**Application by RWE Renewables UK Solar and Storage Limited for the Byers Gill Solar Farm
The Examining Authority's written questions and requests for information (ExQ2)
Issued on 01 November 2024**

Responses are due by Deadline 5: 15 November 2024.

Drawing Title  
**Environmental Masterplan  
Sheet 2 of 13**

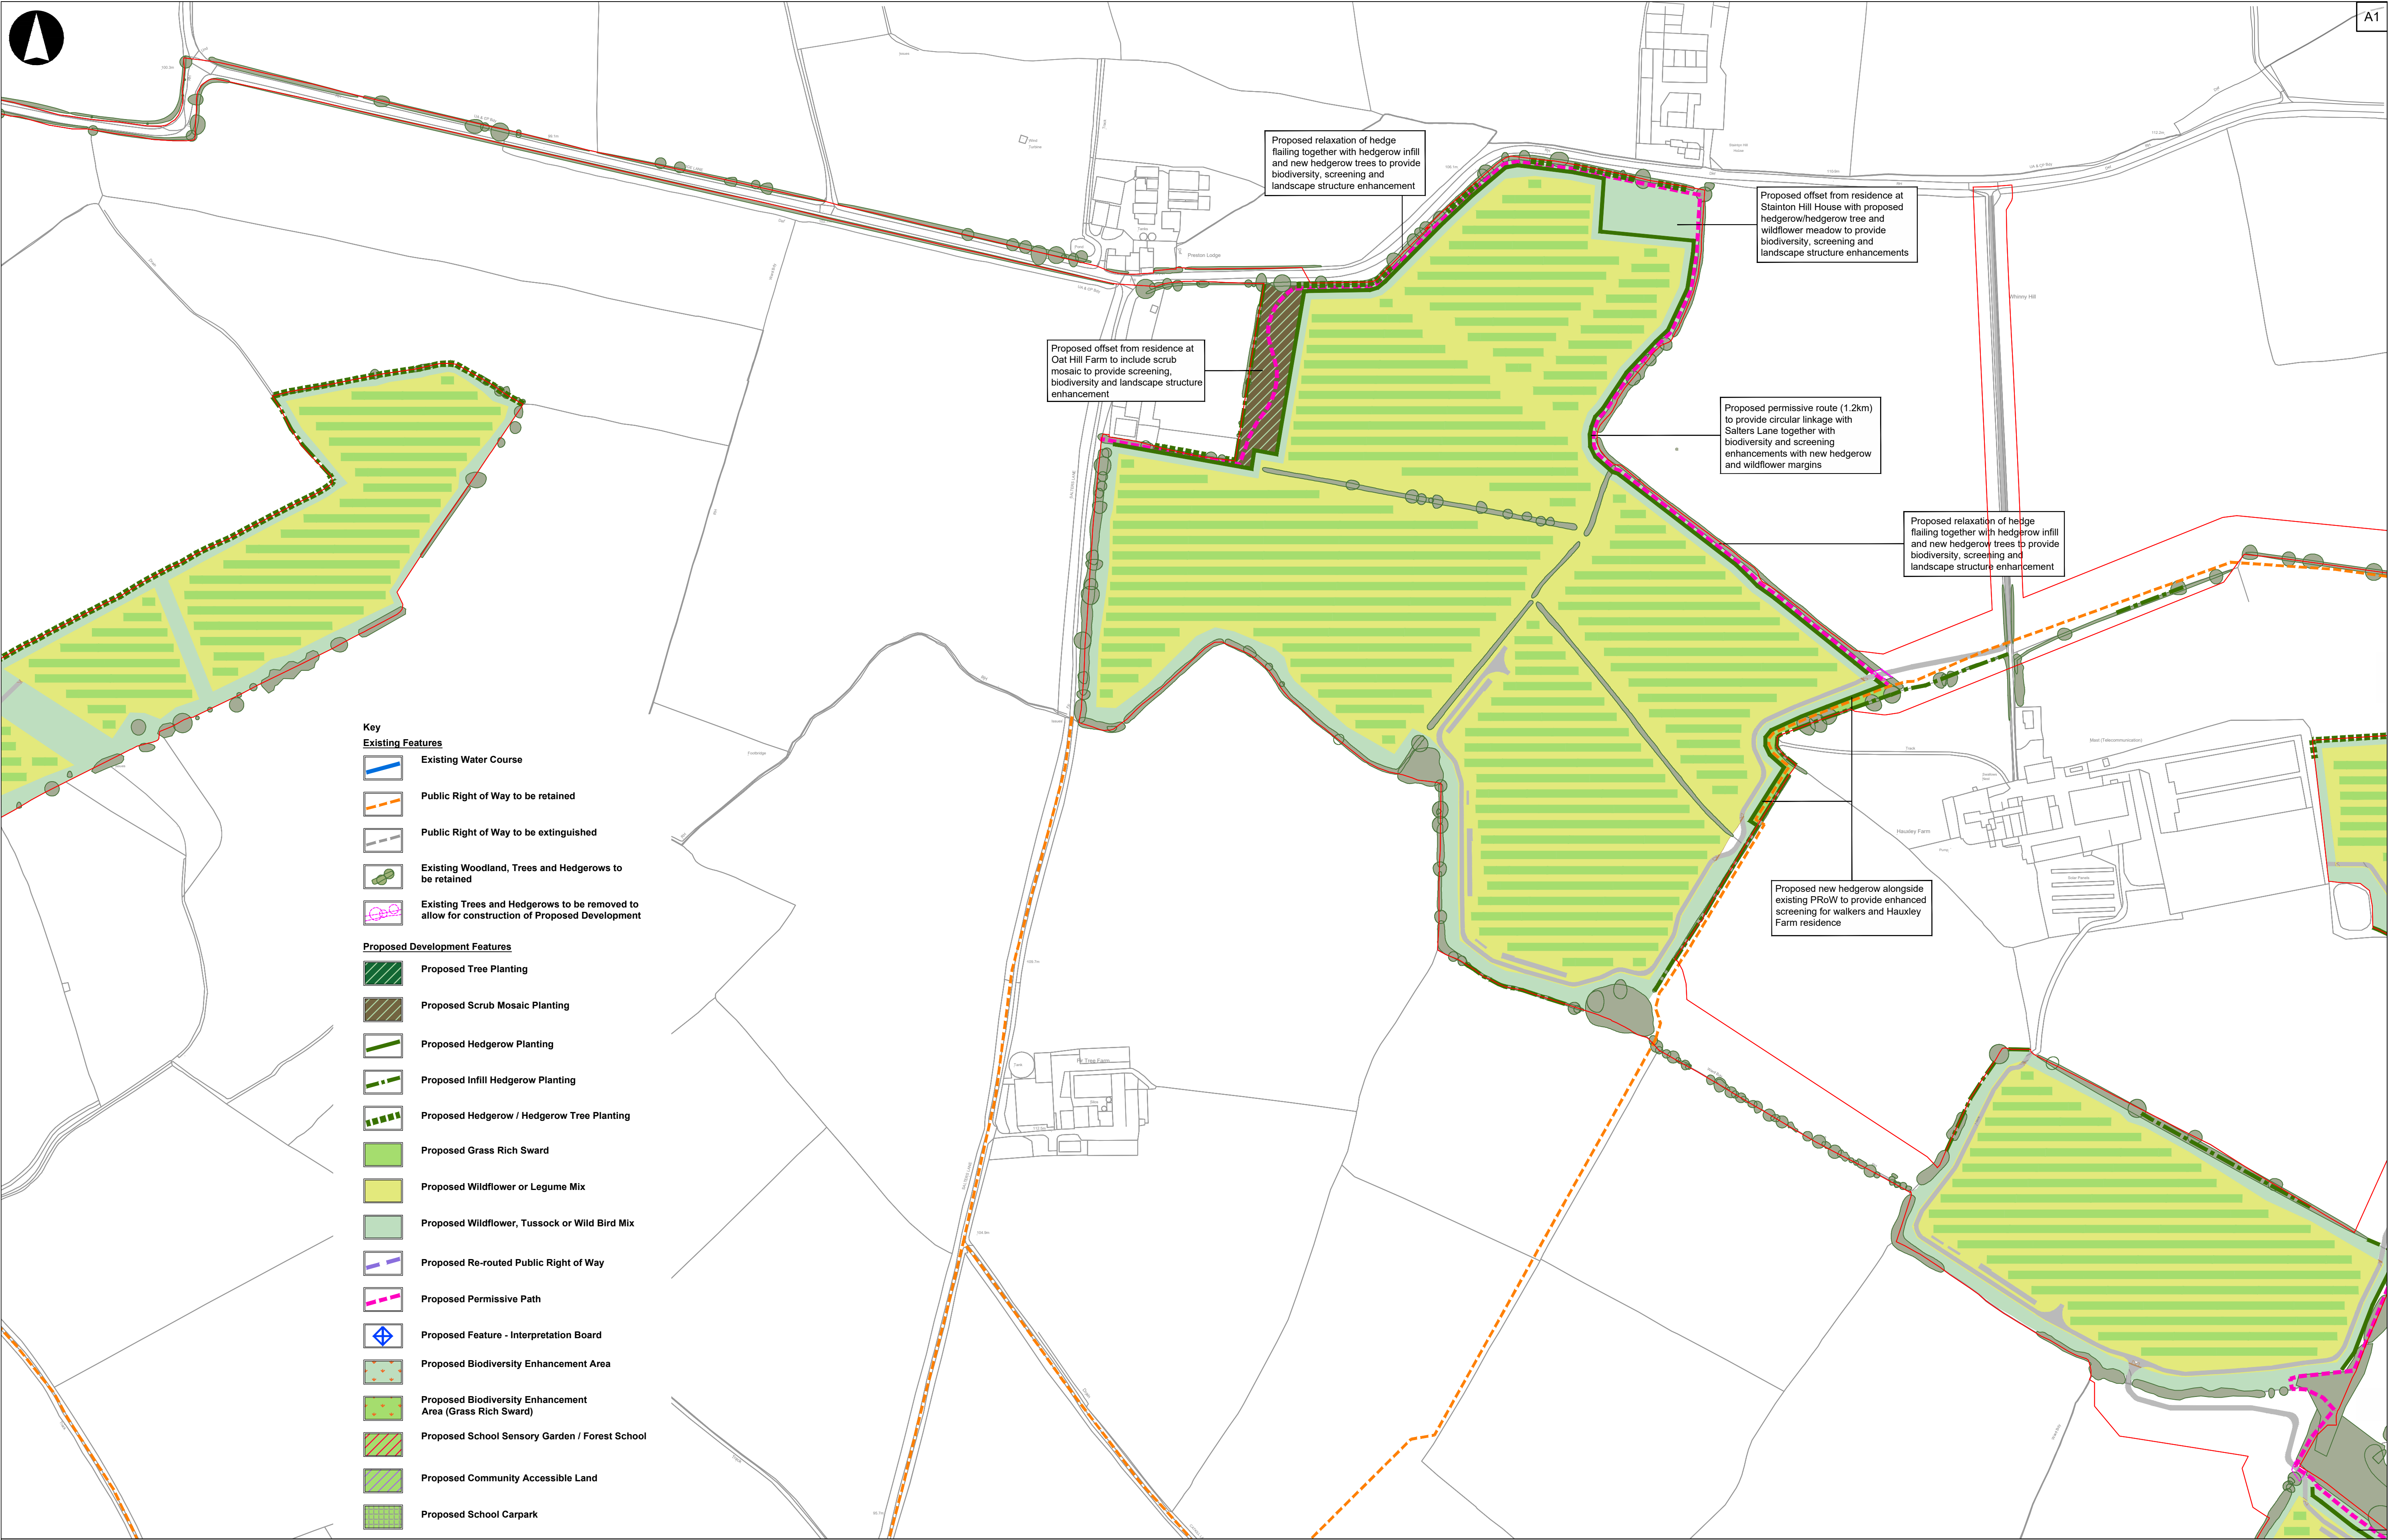
ExQ2	Question to:	Question:
		quantities including specific references to where these are shown on drawings and other application documents.
LSV.2.2	Applicant	With regard to the mitigation works proposed in the area of Oat Hill Farm; Environmental Masterplan Sheet 2 [AS-016] states 'Proposed offset from residence at Oat Hill Farm to include scrub mosaic to provide screening, biodiversity and landscape structure Enhancement.' Please provide greater detail of the mitigation proposed for this property, including visualisations from the property post mitigation at various stages of growth.
LSV.2.3	Applicants	Please add the location of the Viewpoints to the Works Plans and the Street Works, PRow & Access Plans.
LSV.2.4	DBC	Regarding Mill Lane, Bishopton. Please confirm if there is a height restriction to the road hedges for road safety and what this is? In addition, please identify any other locations near the Proposed Development where there are height restrictions to road hedges.
